Permit Number: 060652

has permission to Build a 28' x 34' single family w/ a 25' x 25' two attached garage

AT 33 BALLPARK DR Portland, OR 97205 PL 371 A-044001

Dept: Building **Status:** Approved with Conditions **Rev** 06/28/2006
Note: **Issue:**

This detail should answer the deck framing questions

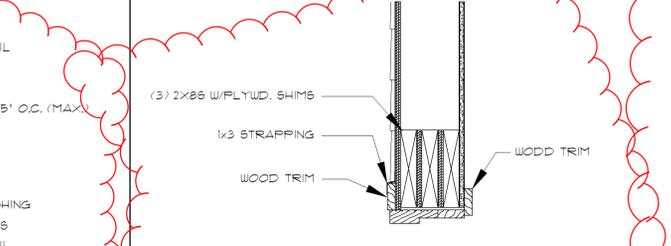
- 1) The Header for the Slide opening must be three (3) 2" x 10" minim; The Header for the front door opening must be three (3) 2" x 8" minim.
- 2) Prior to framing the following details must be submitted and approved:
 - 1) The Header for the Garage Door.
 - 2) Garage Roof framing Plan
 - 3) Deck and guard Framing Plan
 - 4) Egress Window Dimensions
- 3) Smoke Detectors are not shown in the common hall on the Second Floor. Smoke detectors shall be installed in the common area on the first floor. These must be interconnected with the other detectors shown, hard wired with battery back up.
- 4) The basement is not habitable space as it is not insulated and thus unsuitable for "conditioned space".
- 5) A ridge vent must be installed in compliance with Section R806 of the IRC

PROJECT: Lot 14 - #33 Bollopk Drive PORTLAND, MAINE

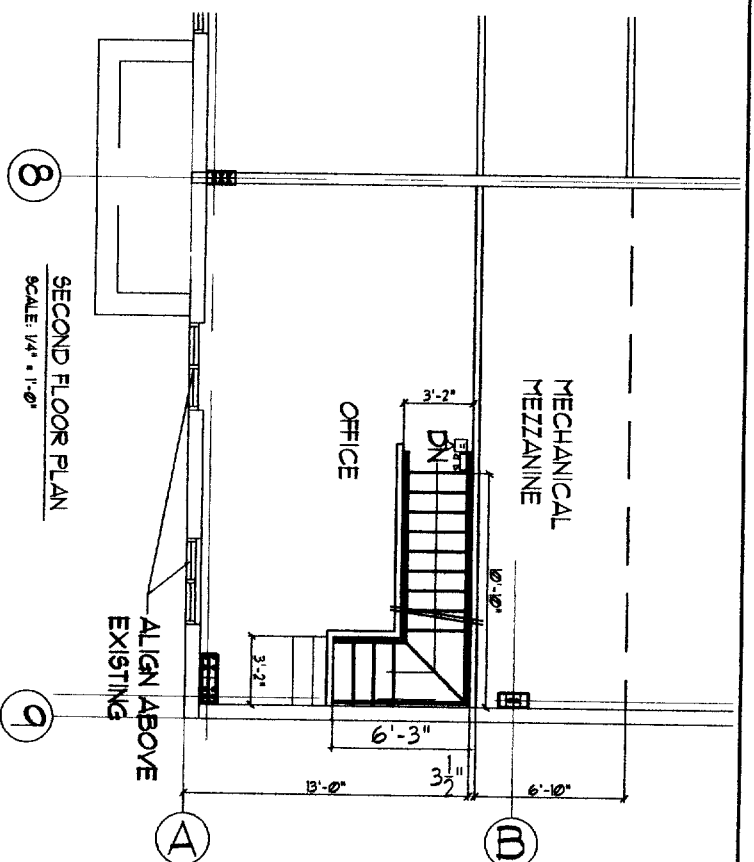
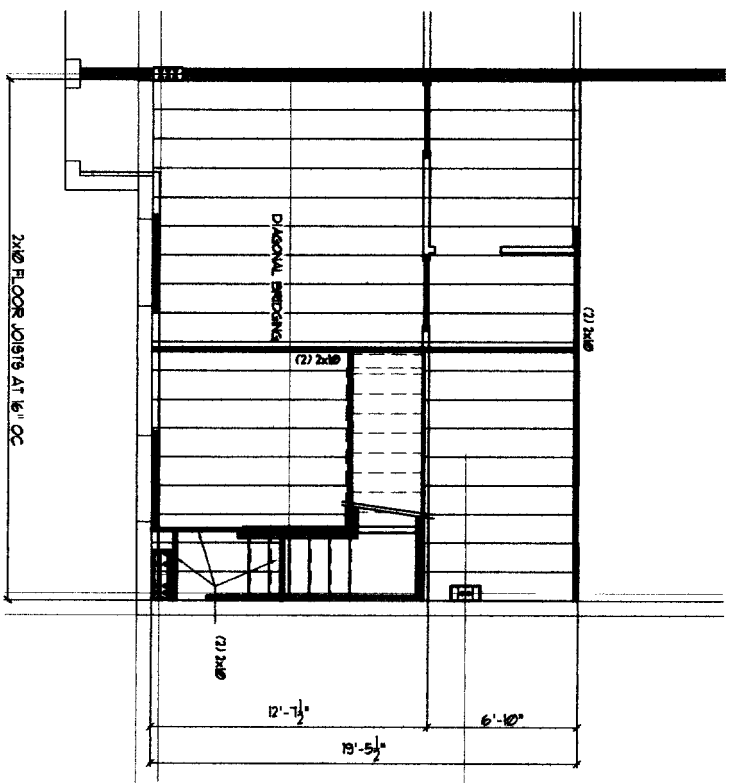
5/18/2006-amachado: Left message with Len Anderson. Site plan has 4' x6' set of front steps and building plans do not show front steps. They need to match.

5/19/2006-amachado: **Len** came in and drew the step on the building plan so now they match.
